10 September 2015

**Application by Highways England for an Order Granting Development Consent for the A14 Cambridge to Huntingdon Improvement Scheme – Proposed Changes to the Application Made by Highways England**

National Grid Gas Plc (National Grid) has reviewed the proposed changes to the application and provides the following comments on each change relevant to National Grid's gas apparatus and contained within document HE/A14/EX/99:

Drawing title: **LAND PLANS REGULATION 5(2)(i) SHEET 21 OF 40**

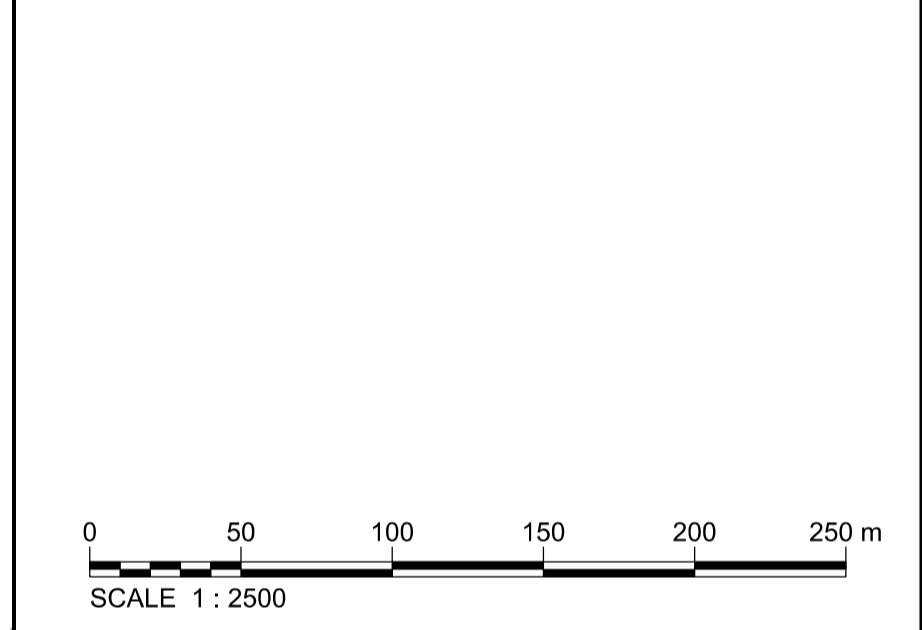
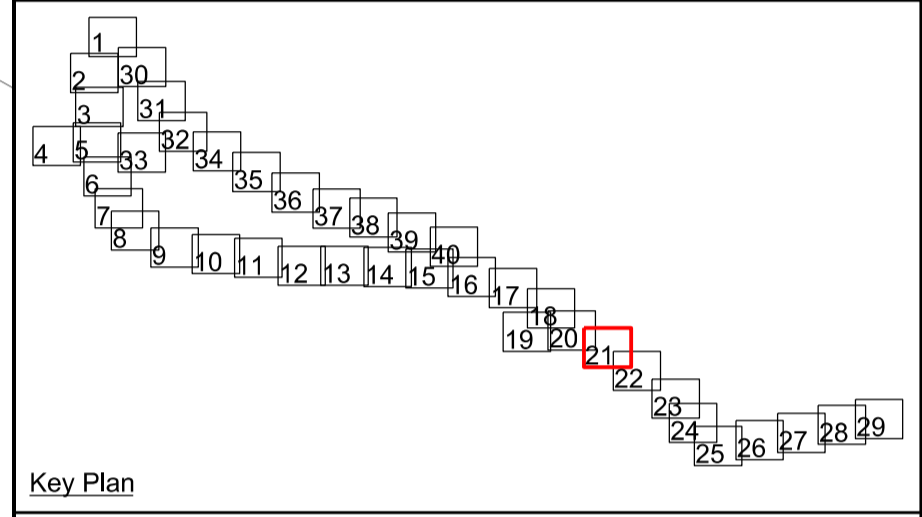
National Grid supports the proposed scheme changes to include additional land identified as plot 21/4h on land plan 21. National Grid notes that Highways England is currently seeking a further revision to DR1.20e, seeking powers to acquire new rights in respect of part of plot 21/4f and part of plot 21/10b (both of which were previously proposed to be subject only to powers of temporary possession). National Grid notes that this amendment is requested by Highways England to ensure that National Grid would have permanent rights in relation to its diverted apparatus in this location. National Grid therefore supports this proposed revision to scheme change DR1.20e.
